**WEST SUSSEX COUNTY COUNCIL
PLANNING SERVICES CONSULTATION**

SUBJECT: AL/115/17/OUT - Outline application with some matters reserved for the erection of 55No. dwellings, sustainable drainage measures, public open space, children's play area, landscaping & all other associated works. This application is a Departure from the Development Plan.

LOCATION: Wings Nursery, Lidsey Road, Aldingbourne, PO20 3SU.

RGP Swept Path Analysis

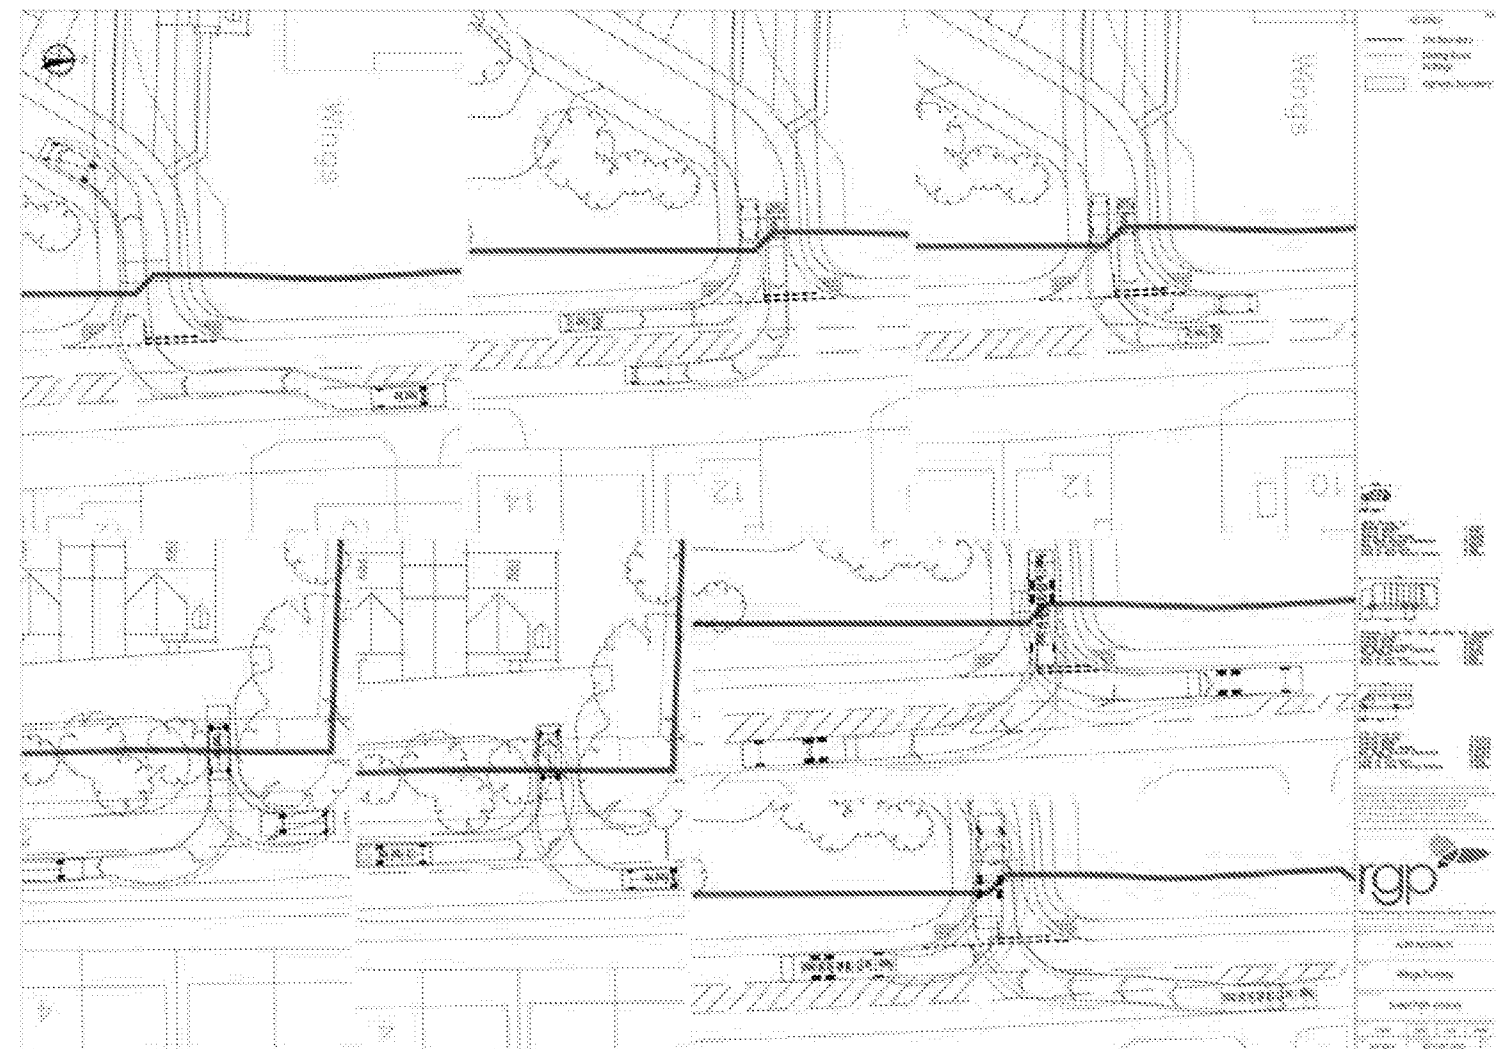
The Highway Authority previously had a concern about movement of larger vehicles through the junction in-so-far that such vehicles may find it difficult to turn into the junction or their path might be blocked while traffic is queuing in the primary site access. However, this has been addressed

The Highway Authority has reviewed the information provided (including swept-path diagrams of vehicles entering and leaving the junction) and the arrangements are found to be satisfactory.

through slight widening of the junction and associated improvements to the turning lane on the A29 Shripney Road itself.
